MEMORANDUM

TO: Jean Fraser, Planner
FROM: David Senus, P.E. & Ashley Auger, E.I.T.
DATE: November 20, 2013
RE: Munjoy Heights, Level III Site Plan Application

Woodard & Curran has reviewed the Final Level III Site Plan Application for the proposed infill residential development located at 79 Walnut Street in Portland, Maine. The project consists of the demolition of two structures and the development of 29 townhouse style residences.

DRAWING NO.
C-45

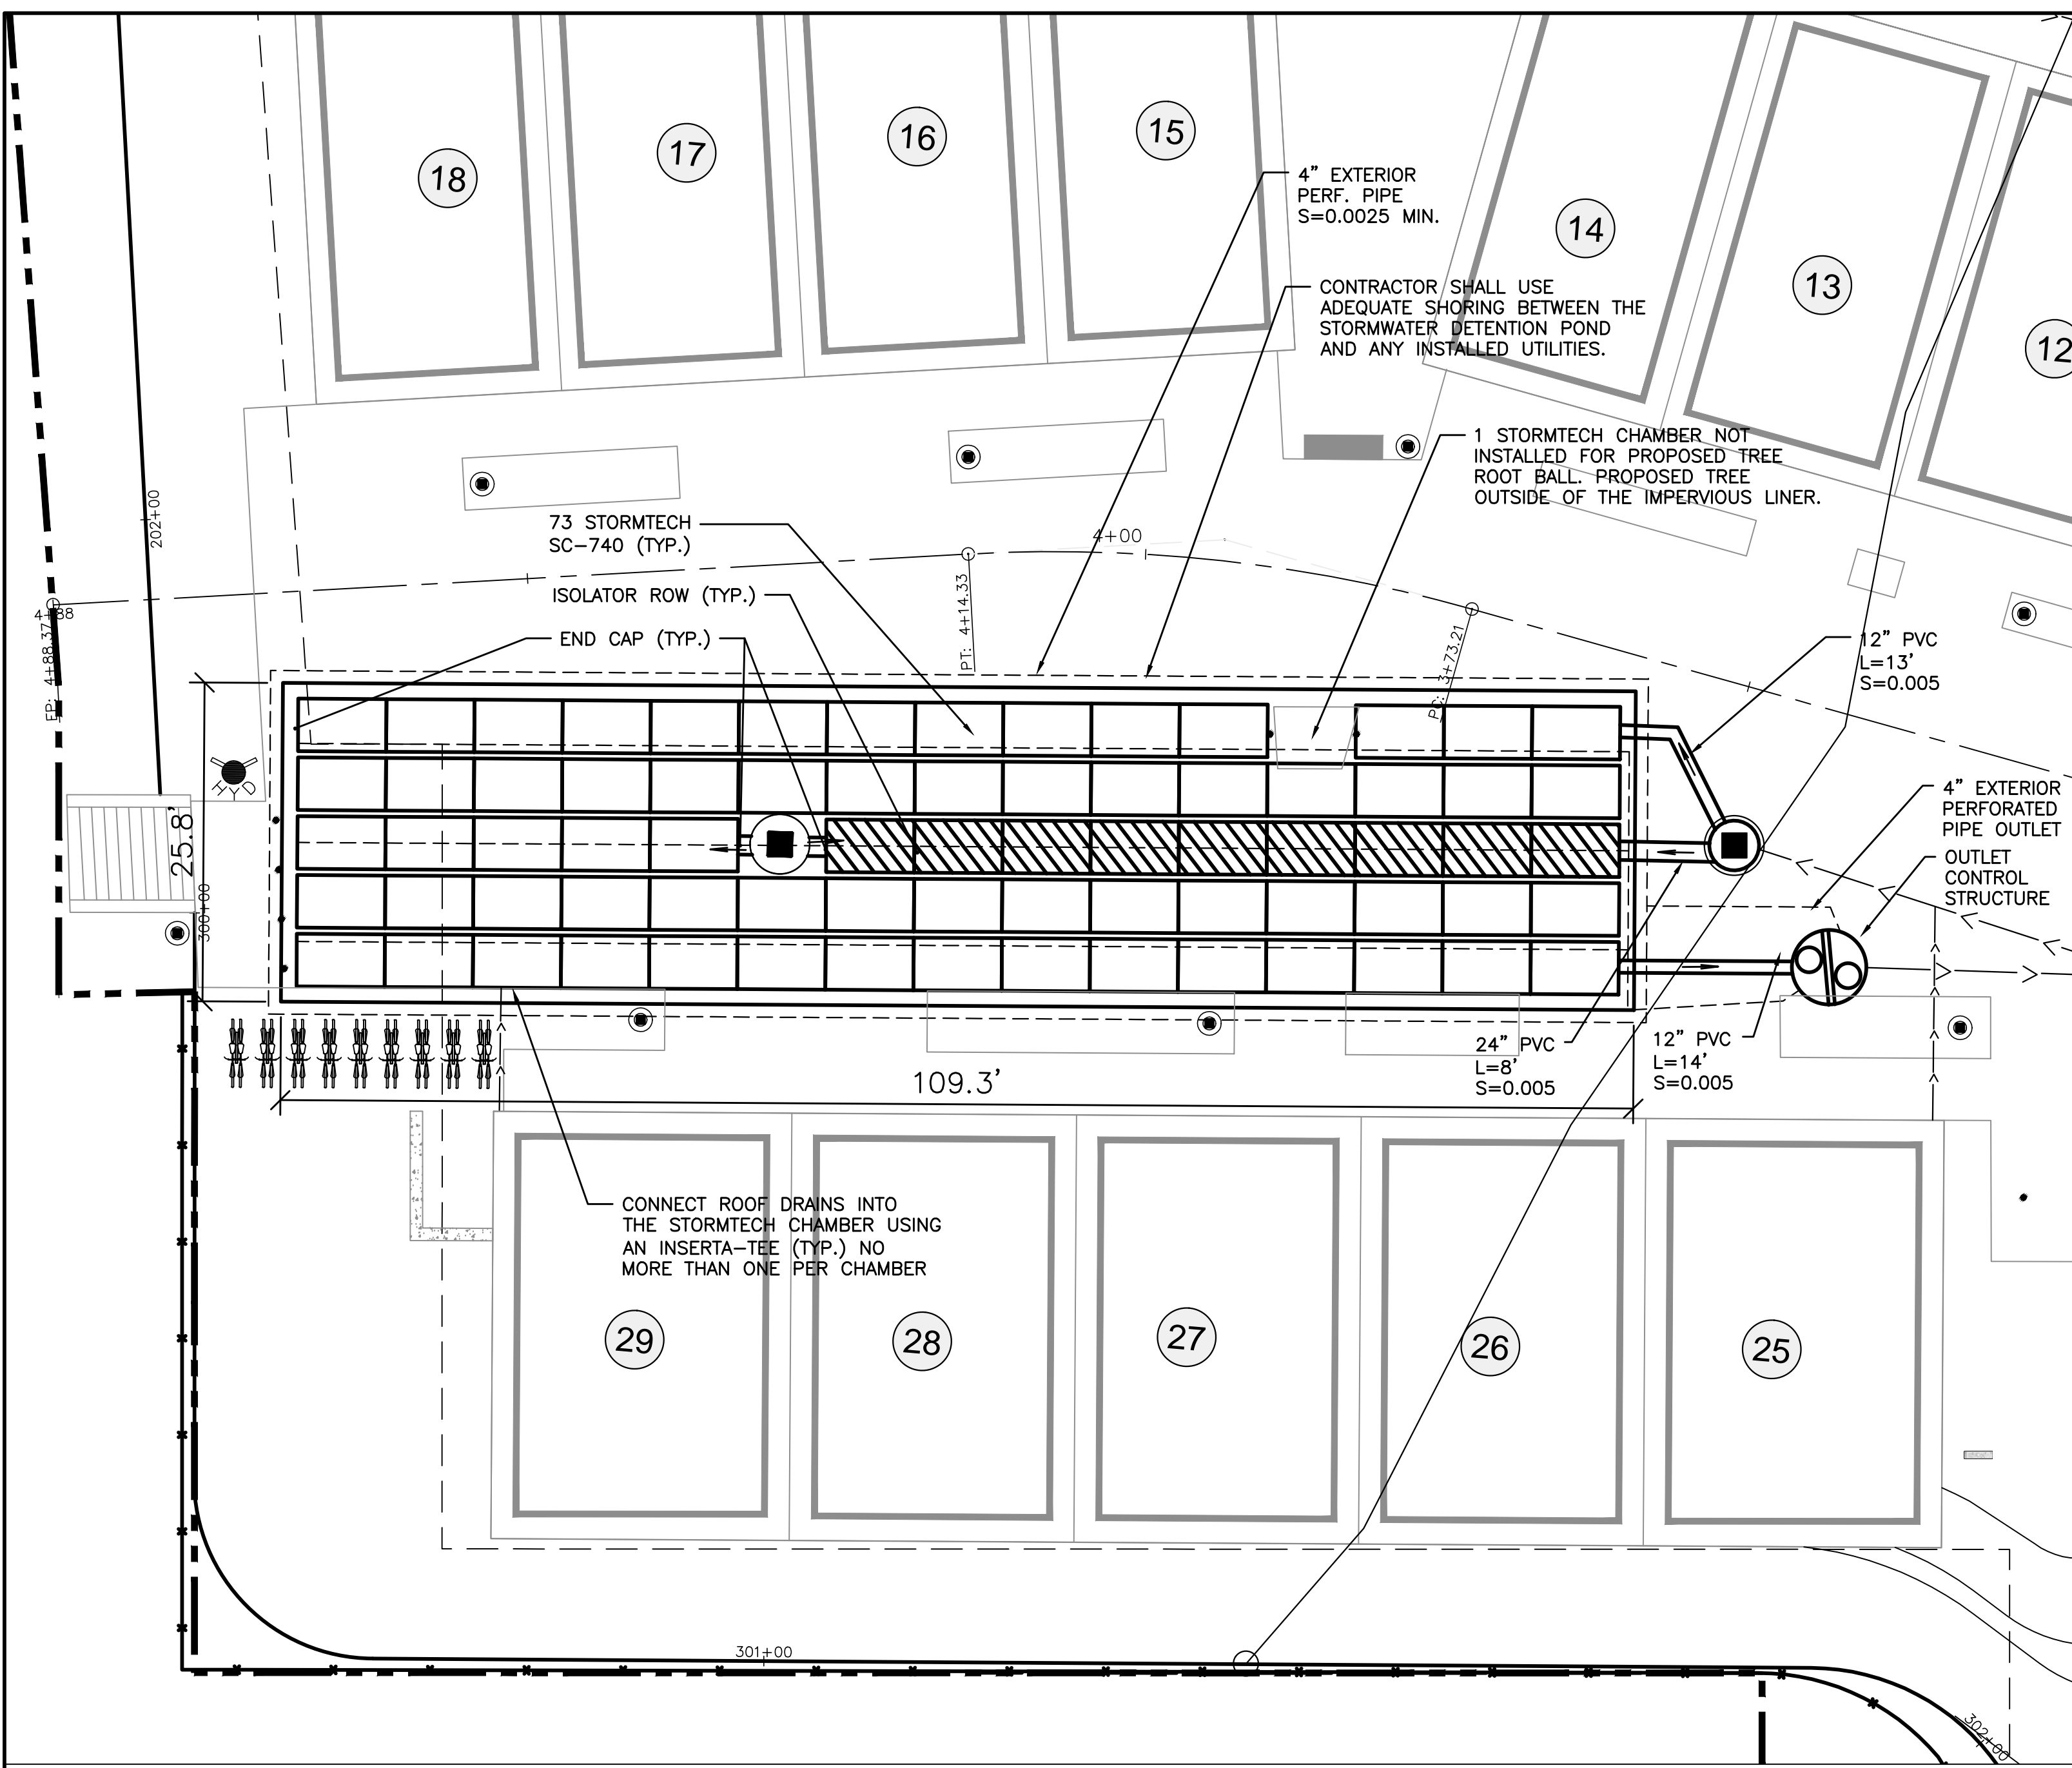
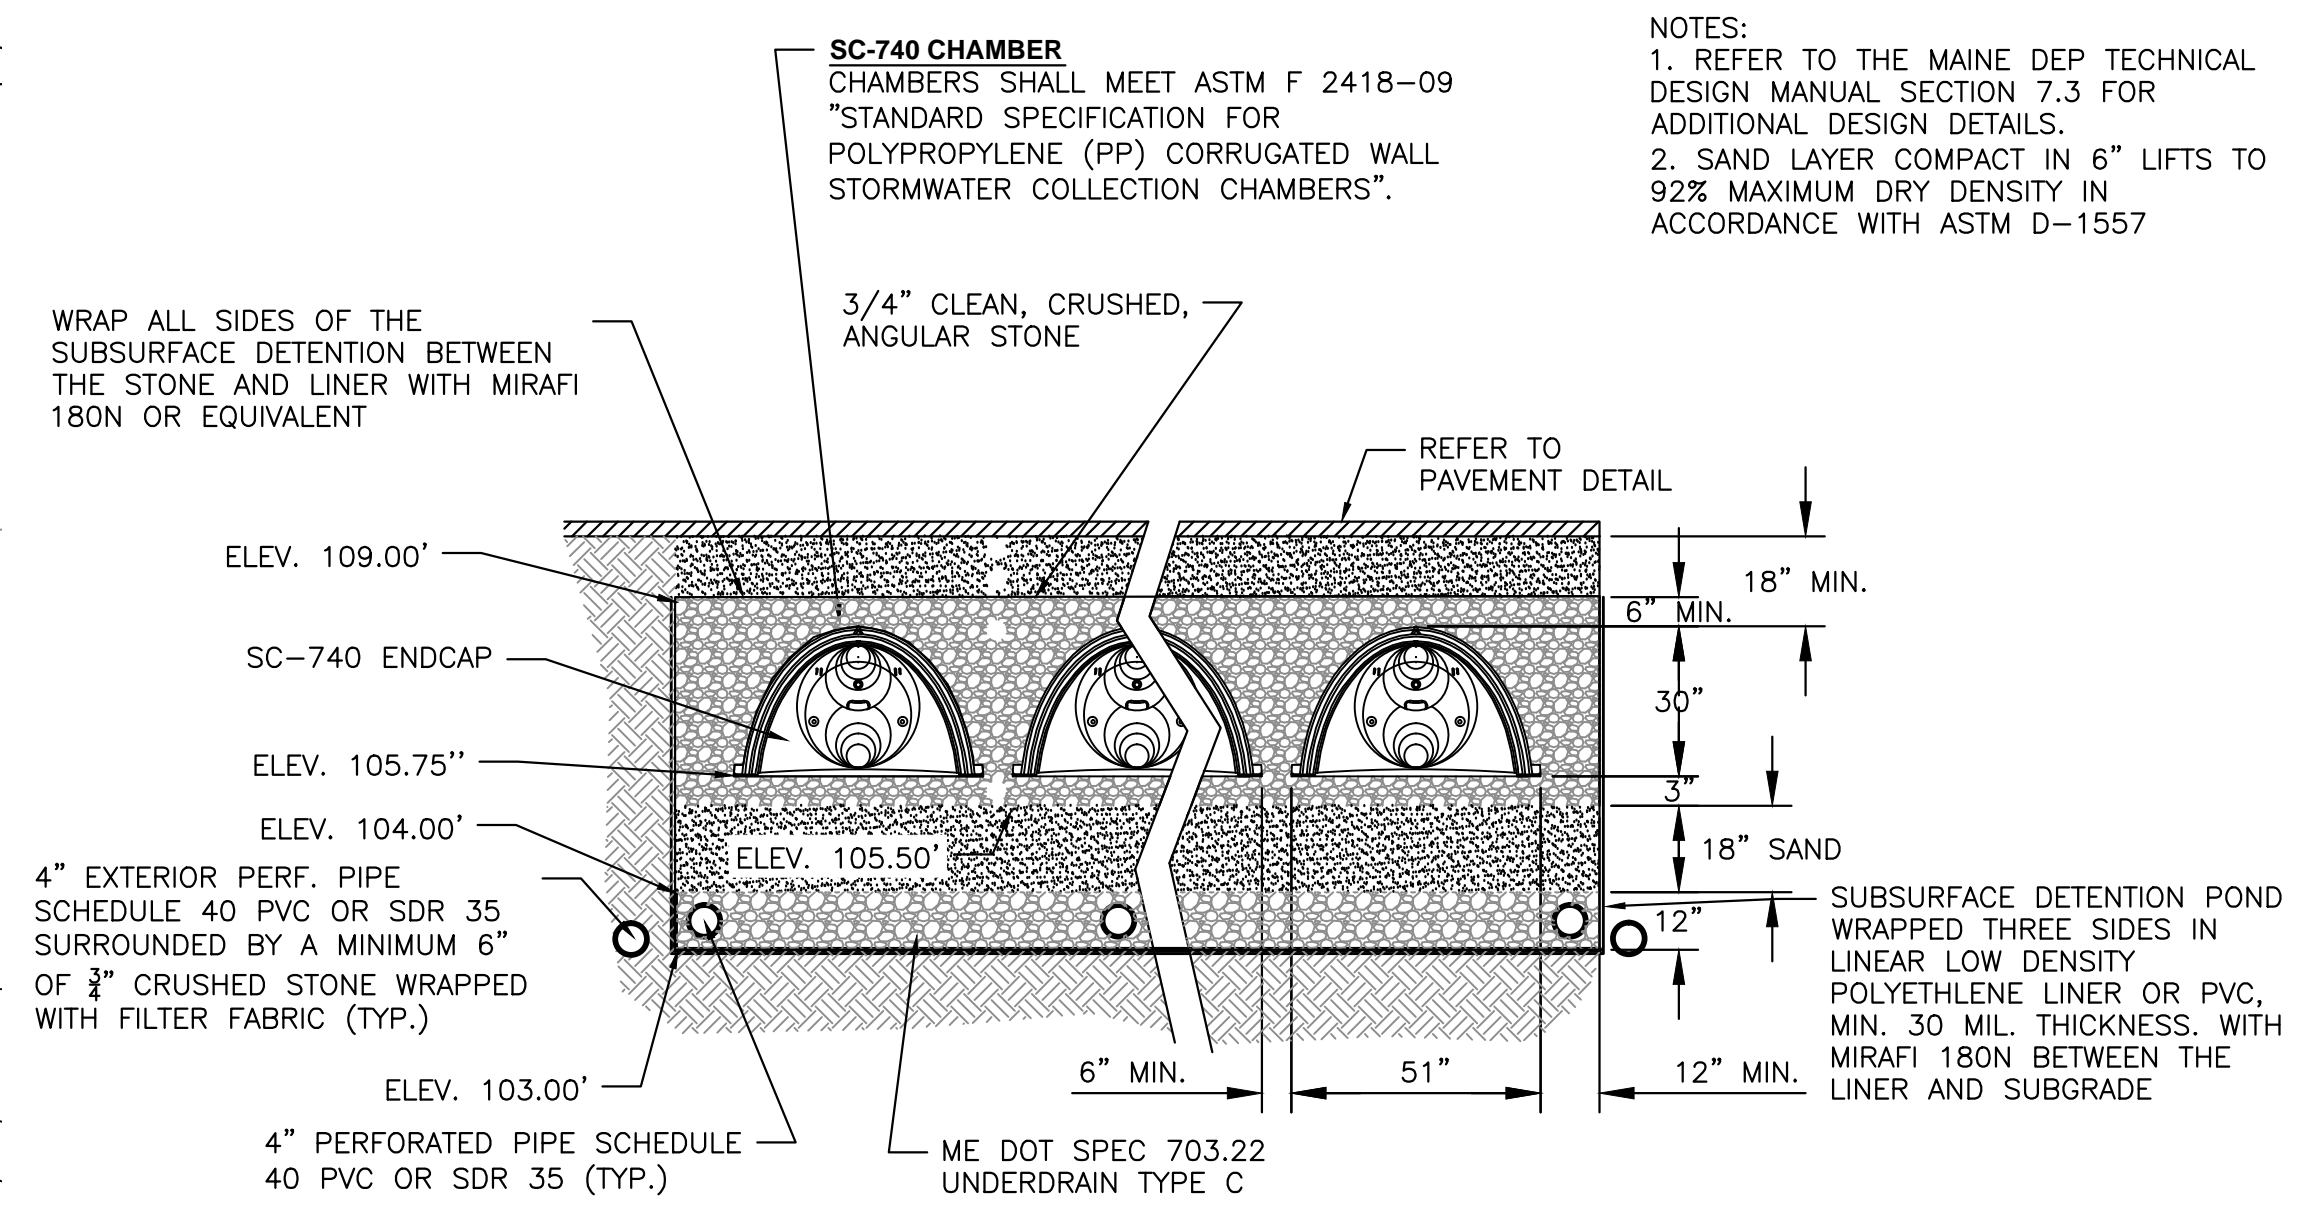
- ii) Pond 1P within the HydroCAD report - the depth of crushed stone in "Volume #2" has been modeled as 3.5-feet; however, it is detailed on the plans as 3.25-feet. The Applicant should clarify and revise as necessary.

- b) StormTech recommends that additional access structures be provided when the length of the Isolator Row exceeds 50 feet. The structure may be added at the opposite end of the Isolator Row or in-line with the Isolator Row at every 50 foot interval.

- c) Future submissions should clarify the pipe invert elevations currently indicated as "TBD".
 - d) The Applicant should provide a detail for the proposed Access/Diversion Structure for the Isolator Row, specifically the pipe connections from this structure to the USSF.

| DRAWING NO. C-30 | |

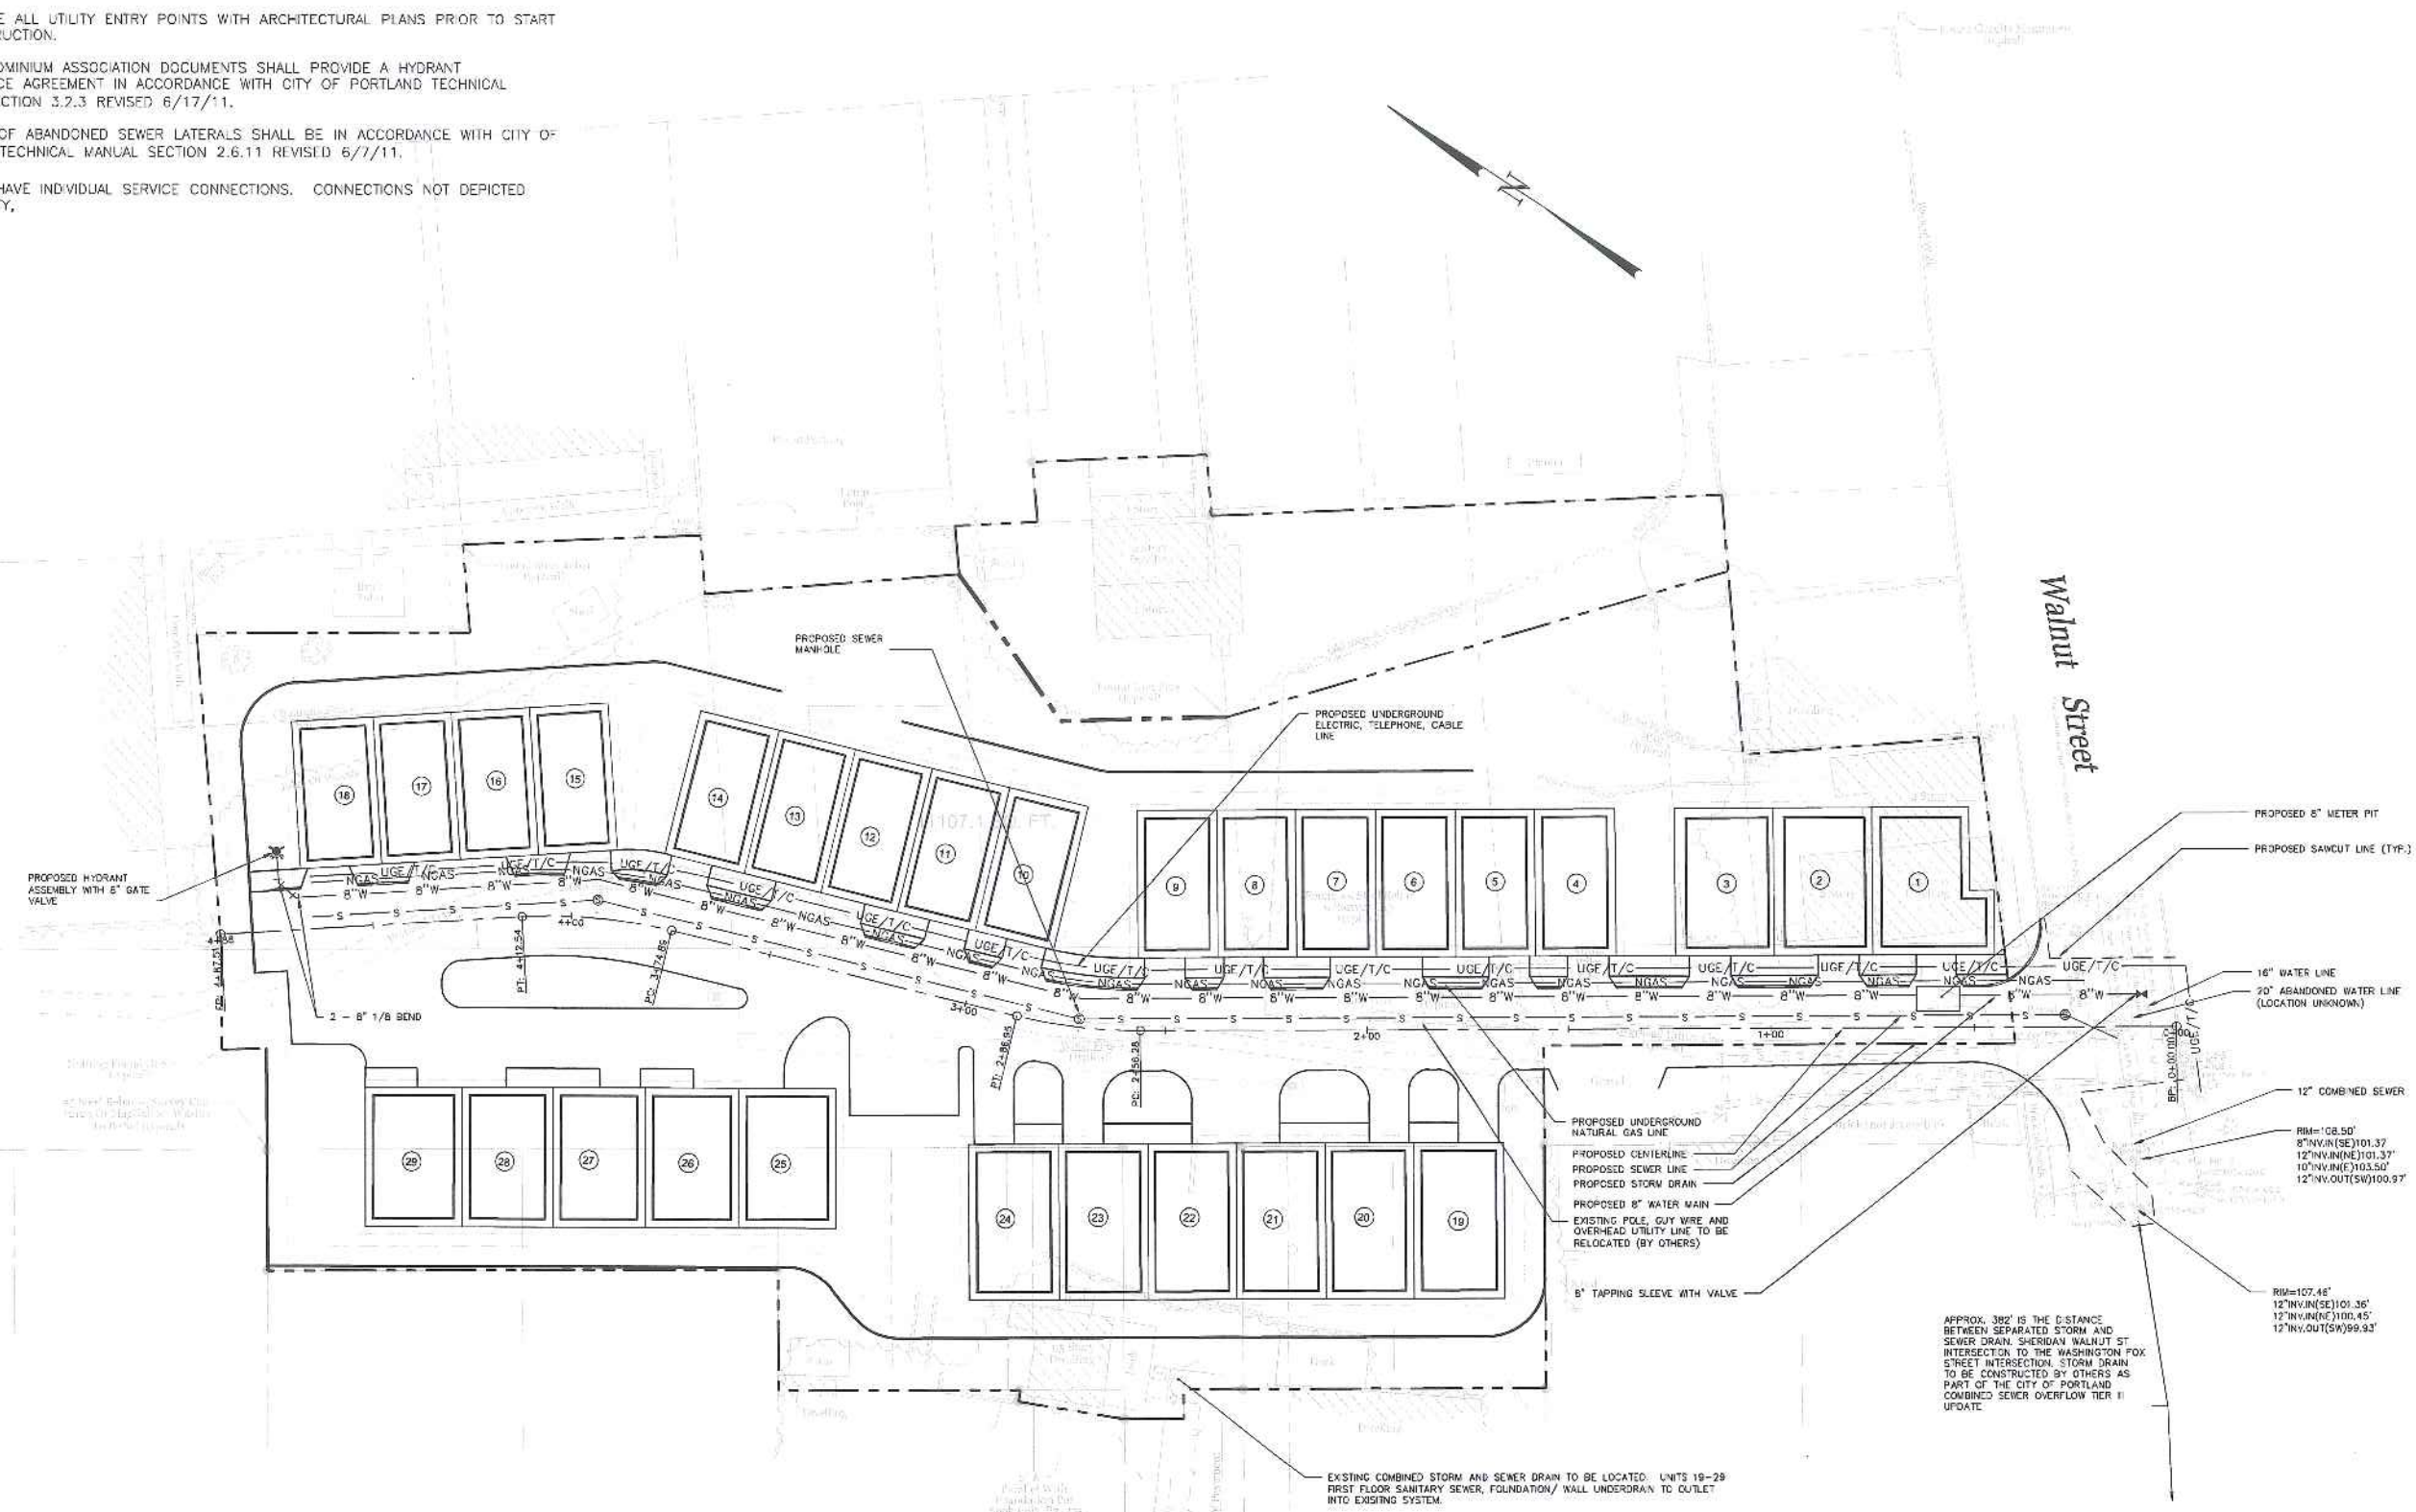
- 17) Sheet C-30 indicates a proposed location for potential rain gardens. Future submissions should clarify the design of these rain gardens.
- 18) Sheet C-30, additional detail should be added to the grading and drainage plan to ensure that runoff from the driveway does not enter onto the Rando Parcel (south/west of the entrance driveway).

- 19) Sheet C-30, the foundation and retaining wall underdrains shall not be allowed to connect to the existing combined sewer on East Cove Street. Per consultation with City DPS staff, the Applicant shall be allowed to run a separated storm drain line for these "clean" water connections to the combined sewer on Washington Avenue for future separation. Agreements for work in East Cove Street would be required from the abutting landowners.

- 20) Sheet C-30, it is unclear how building roofs are connected to the stormwater collection system.
- 21) Sheet C-30/C-43, the Applicant should provide a detail for temporary catch basin inlet protection in addition to indicating the proposed location(s) on the plan.
